**Application Reference:** 2026/0253

**Site Address:** 5 Catania Rise, Darfield, Barnsley, S73 9QZ

**Introduction:** This application seeks full planning permission for a rear extension to detached bungalow and demolition of existing garage

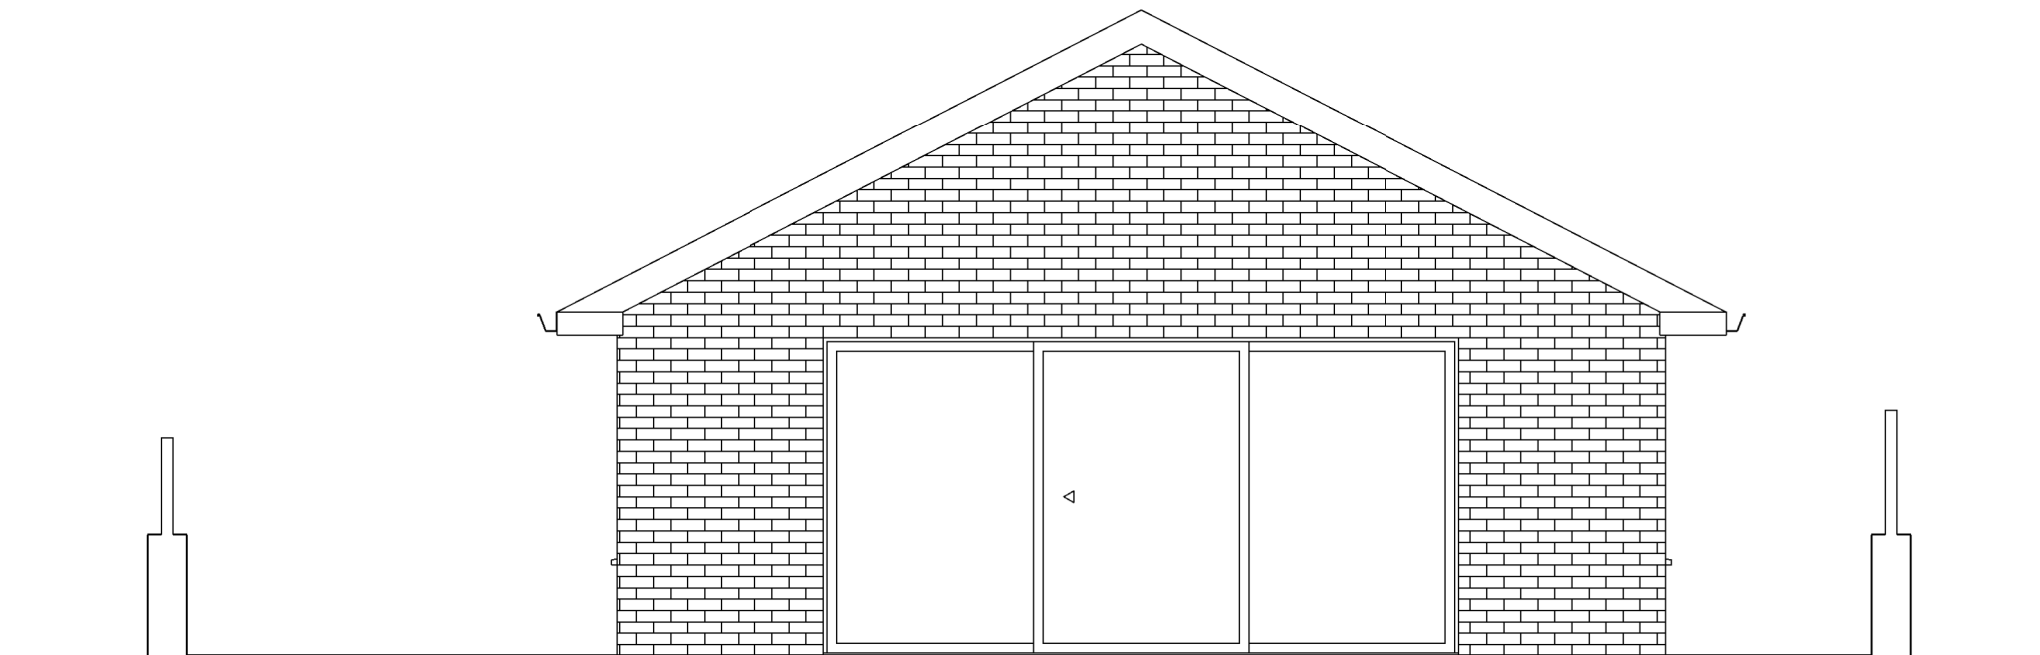
Excluding the proposed height of the proposal which at approximately 4.25m high exceeds the 4m allowance of permitted development, the width, rear projection and choice of materials would all be in accordance with permitted development rights. In terms of SPD guidance, this is a rear extension not prominently visible from public view, and the eaves are no higher than 2.5m, which meets the SPD guidance

With the proposal matching the width and height of the existing bungalow with a roof extension of similar appearance, the proposed extension is quite literally an extension of the existing dwelling. The only noticeable external difference to the original bungalow is the inclusion of a larger glazing unit on the rear elevation of the dwelling. Internally the dwelling, despite an extension, would be reduced from a three to two bedroomed home, but this does not require planning consent.

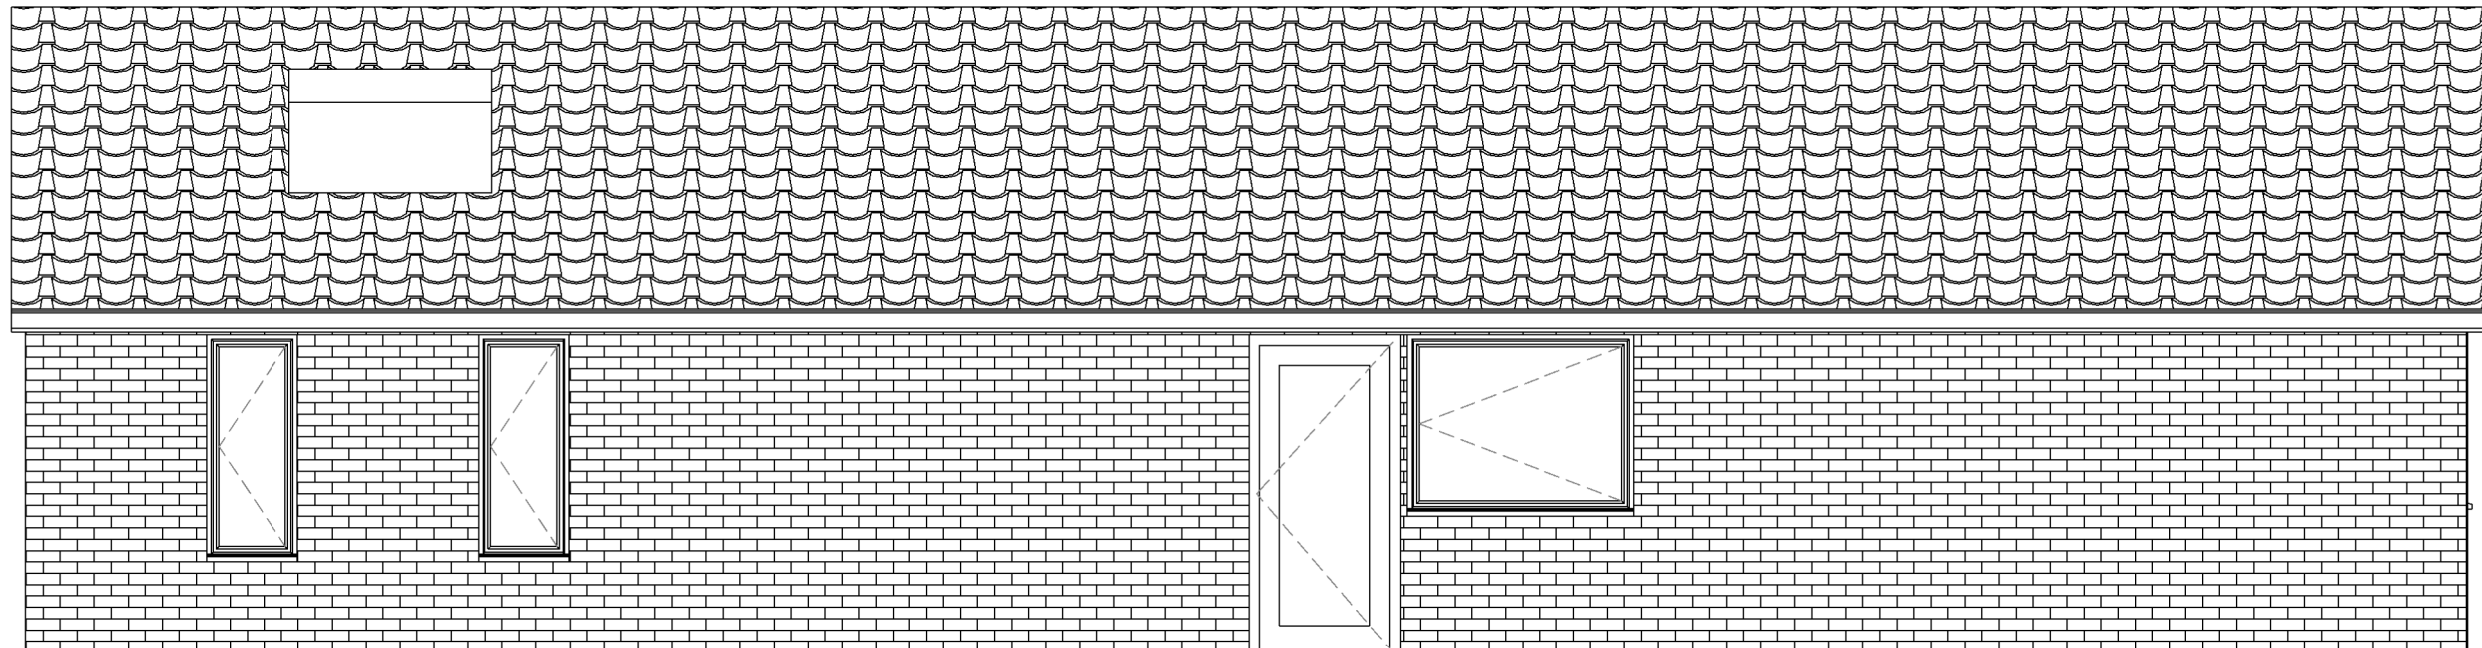
In contrast to No7, the neighbouring dwelling at No3 features its own garage, located towards the end of the side elevation adjacent to the application dwelling, and extends along the side elevation of their rear extensions. Leading up to, and along the garage are two relatively low wooden fences, with a higher wooden fence continuing beyond the garage. As No3 has been previously extended, and without a high boundary treatment, there is a window in the side elevation of the extension which directly overlooks the applicant's garden. With two small windows proposed within the side

elevation of the extension, these would mutually overlook the existing extension, and potentially directly overlook the side elevation window of the neighbouring dwelling.

To resolve the issue of overlooking the neighbouring dwelling, and to avoid any unnecessary design changes, it was agreed that the two small windows overlooking No3 would feature obscured glazing and be conditioned to that effect. With the new internal space being a large open plan area with a large glazing/door unit overlooking the rear garden, and two small windows overlooking the boundary fence, there would be sufficient natural light, as the obscured glazing would not lock out all light, and an acceptable outlook, particularly of the rear garden would remain for the occupants of the dwelling.

- Due to potential overlooking concerns to a neighbouring dwelling, obscure glazing for two small side elevation windows have been agreed, and would be added as a planning condition.
